Our Ref: EN010119

Date: 6 June 2025

### **Application by North Falls Offshore Wind Farm Ltd for an order granting development consent for the North Falls Offshore Wind Farm project**

#### **Request for further information**

Figure 4.6 Overview of Princess Elisabeth Energy Island Exclusion Zone

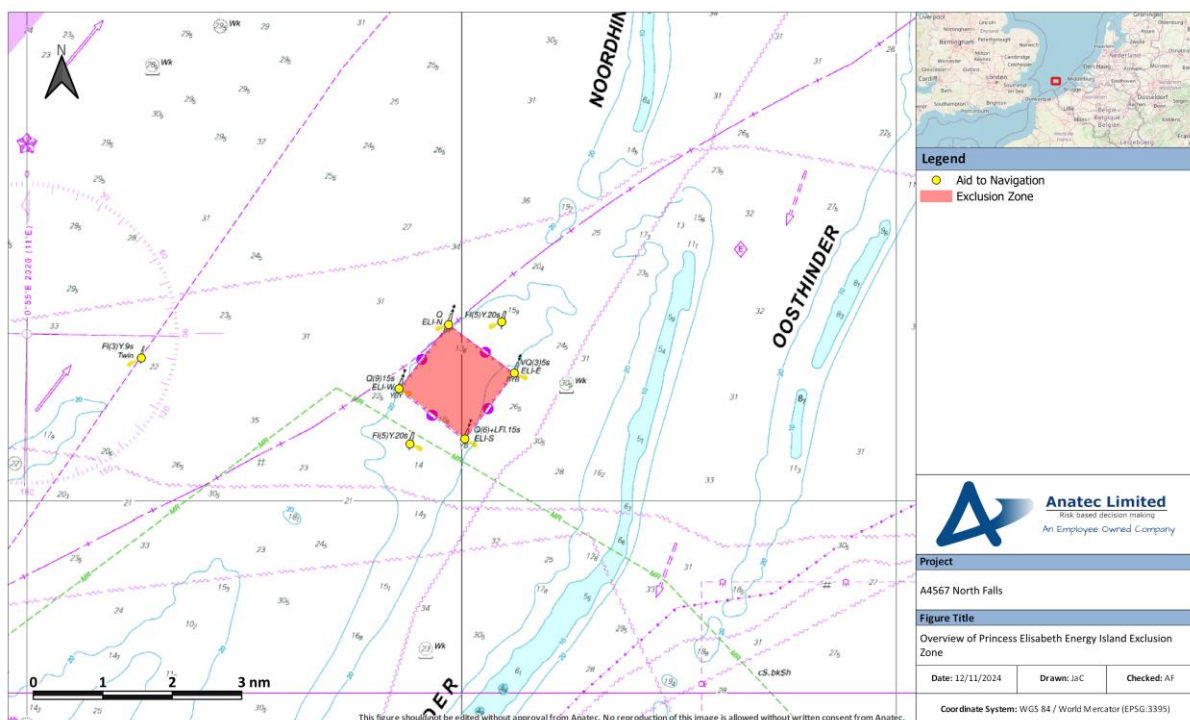
It is also stated that the Princess Elisabeth Island has already begun construction, and an exclusion zone is in place over the historic (South) route. This is illustrated by the figure below (Figure 4.6 from the FSA [Formal Safety Assessment] [REP2-025]).

Figure 5.1 Historic Ostend Routes

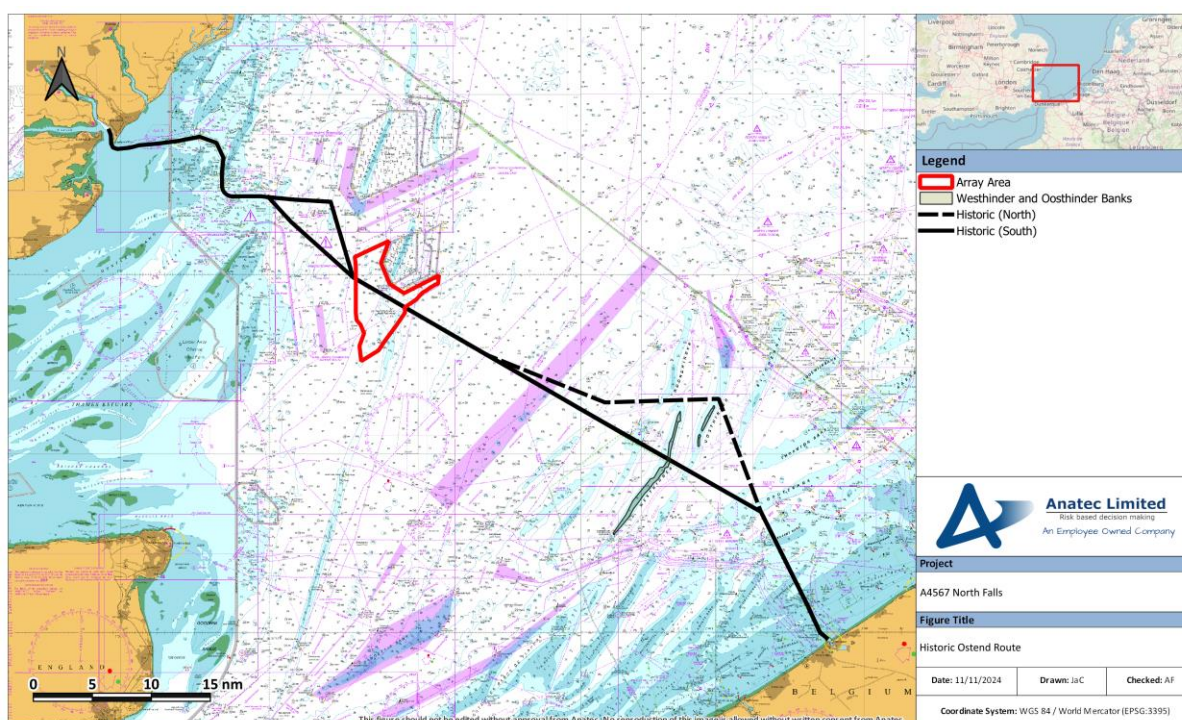
Figure 5.1 of the FSA [REP2-025] shows the Historic Ostend Routes below.

1. Given that the future case route in Figure 6.6 (above) between the south of the Princess Elisabeth Zone (PEZ) Area 1 and the north of the PEZ Areas 2 and 3 appears similar to the historic Galloper recommended route (North route) shown in Figure 5.1 above, the ExA requests that the Applicant confirms whether these routes are the same or similar, and also if formal approval of the removal of the Galloper recommended route has been sought, or is planned to be sought, as part of the Princess Elisabeth Island project?

Figure 6.6 Routing Constraints – Future Case (i.e., with Princess Elisabeth Zone)

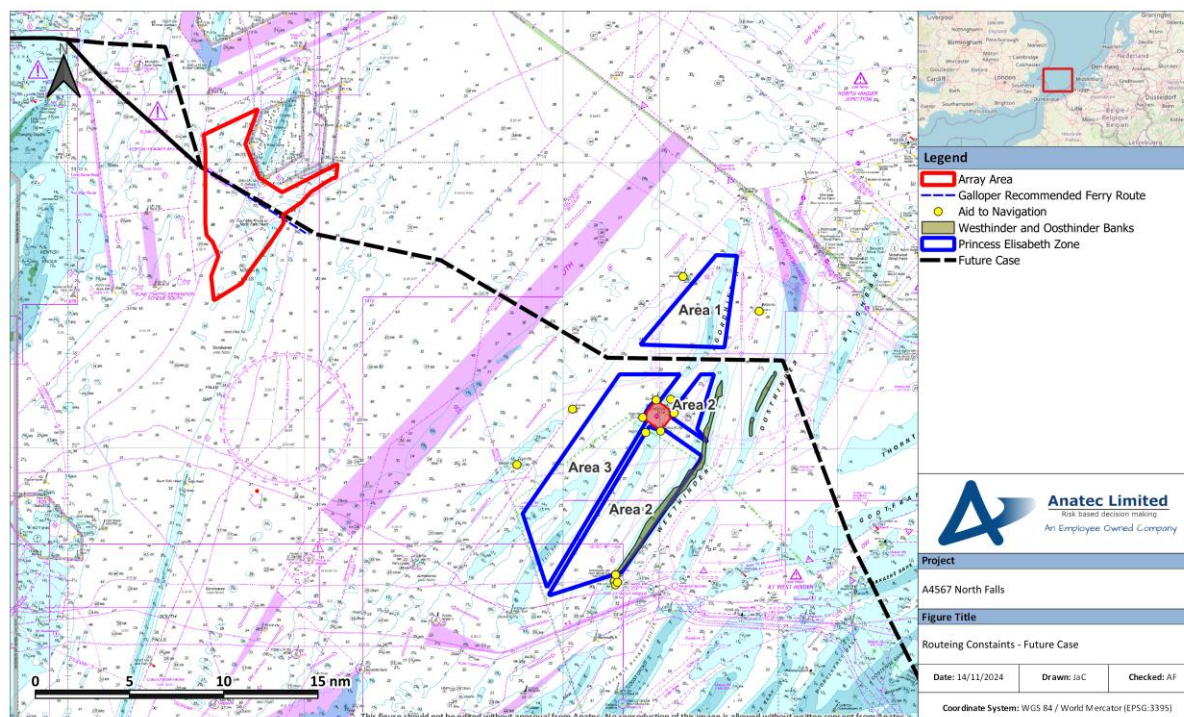
Figure 6.6 from the FSA [REP2-025] is shown above.
